Rezoning Transportation Analysis

Petition Number: 2022-192

From: Jake Carpenter, PE

Date	Description
3-22-23	First Review (TM)

RZ-1.0

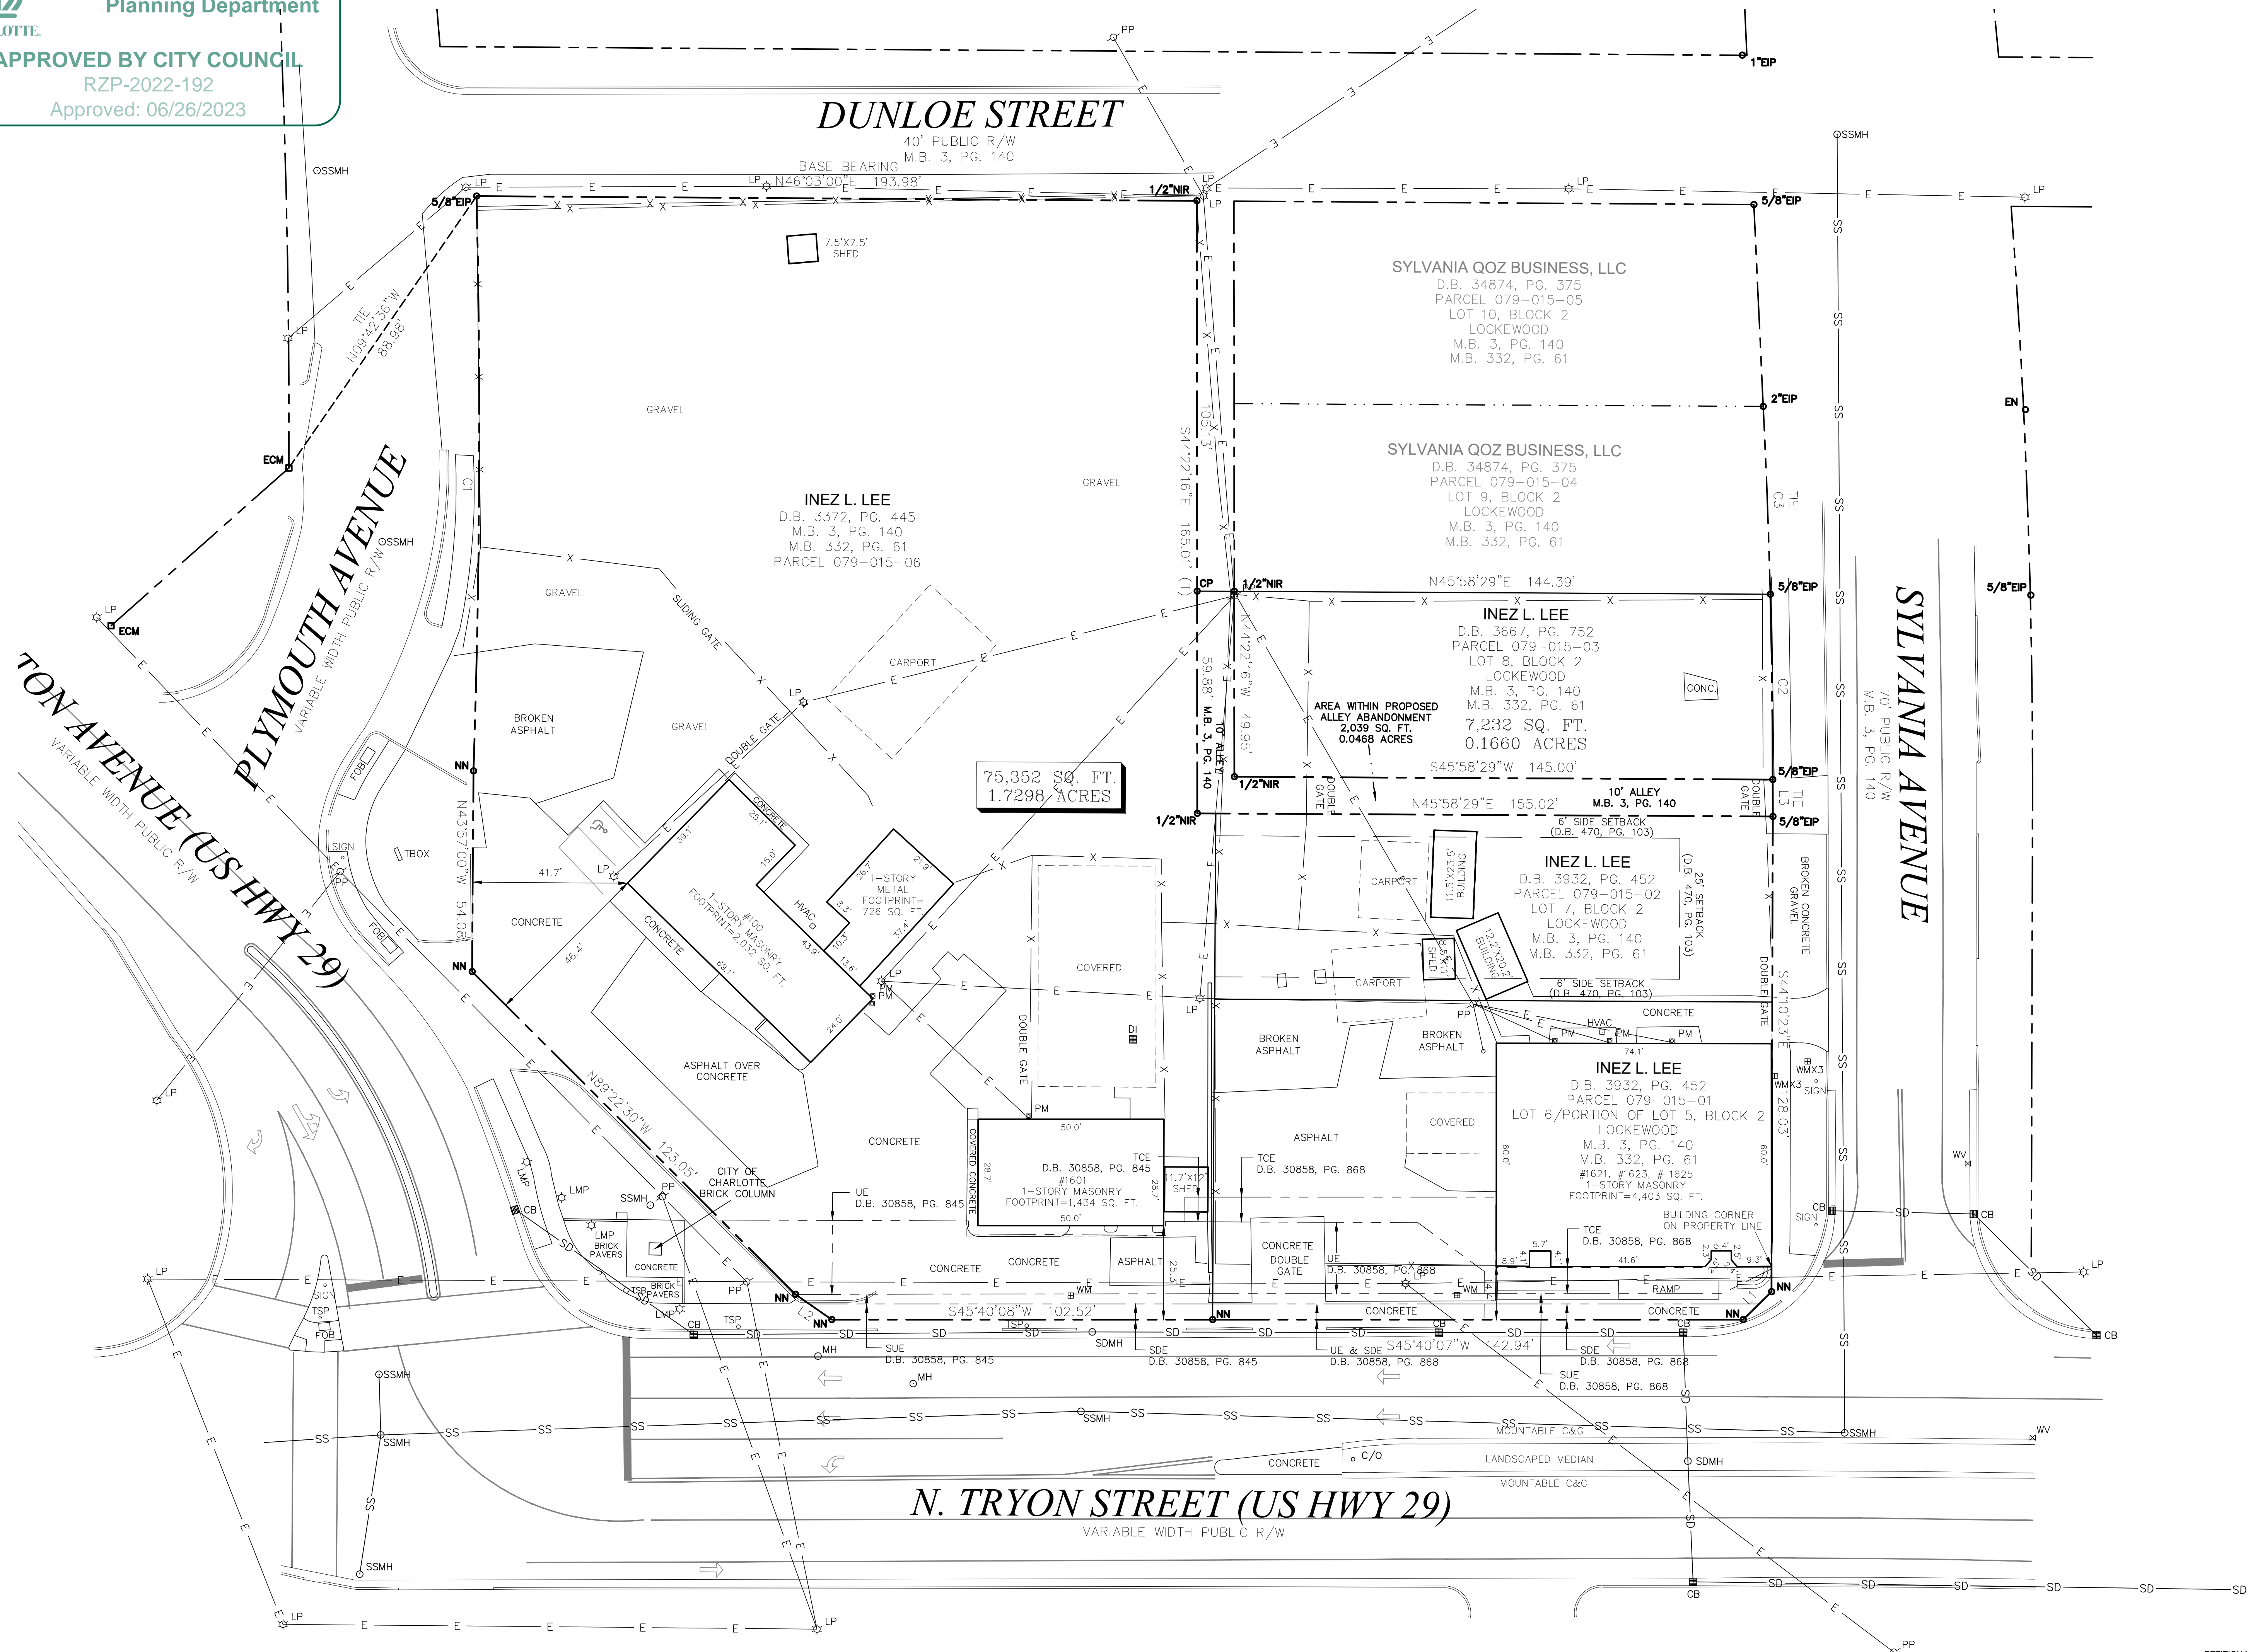
- Tryon Street:** location of future curb and gutter to be moved 38-feet from roadway centerline or 8-feet from back of existing bike lane to accommodate the Charlotte Streets Map with a roadway section of 4+ Avenue and Buffered/Separated Bike Lanes. Add conditional note that the curb line location is to be finalized during permitting in coordination with CDOT to accommodate Charlotte Streets Map.

- Dalton Street:** location of future curb and gutter to be moved 35-feet from roadway centerline to accommodate the Charlotte Streets Map with a roadway section of 4+ Avenue and Bike Lanes. Add conditional note that the curb line location is to be finalized during permitting in coordination with CDOT to accommodate Charlotte Streets Map.

Label and dimension the curb and gutter from the centerline for each road on the site plan.

4. Revise site plan and conditional note(s) to commit to dedicate a minimum of 40-feet of right-of-way from the Tryon roadway centerline. The site plan shall label and dimension the right-of-way from the road centerline.

5. Revise site plan and conditional note(s) to commit to dedicate a minimum of 40-feet of right-of-way from the Dalton Street roadway centerline. The site plan shall label and dimension the right-of-way from the road centerline.

6. Revise site plan and conditional note(s) to commit to dedicate a minimum of 28-feet of right-of-way from the Dunloe Street roadway centerline. The site plan shall label and dimension the right-of-way from the road centerline.

7. Revise site plan and conditional note(s) to commit to dedicate a minimum of 36-feet of right-of-way from the Sylvania Avenue roadway centerline. The site plan shall label and dimension the right-of-way from the road centerline.

8. Revise site plan and conditional note(s) to commit to construct an 8-foot planting strip, and 8-foot sidewalk on all frontages per Chapter 19. The site plan shall label and dimension both items from the back of curb and gutter or edge of pavement.

10. Revise site plan and conditional note(s) to commit to construct bicycle facilities by locating the curb and gutter 38-feet from the Tryon Street center line and installing buffered bike lanes on Tryon Street to meet the Council-adopted Charlotte BIKES Policy.

11. Revise site plan and conditional note(s) to commit to construct bicycle facilities by locating the curb and gutter 35-feet from the Dalton Street center line and installing bike lanes on Dalton Street to meet the Council-adopted Charlotte BIKES Policy.

12. Revise site plan and conditional notes to commit to relocating the site access 20-feet from the property line in coordination with CDOT in the event that the neighboring property does not agree to a shared access agreement.

13. Revise site plan and conditional notes to state that final location of shared access alley to be coordinated during permitting.
14. Revise site plan by placing the 50x50 CDOT sight triangle and 10x70 NCDOT sight triangle in the proper location on the site plan.

15. Revise site plan and conditional notes to commit to revising existing curb ramps along site frontage to meet current standards. Landing strip/Truncated dome width must match width of sidewalk being installed.

16. **CDOT REQUEST from 03-23-23: CDOT request that the petitioner connects the proposed sidewalk to the intersection of Sylvania Avenue and Dunloe Street.**
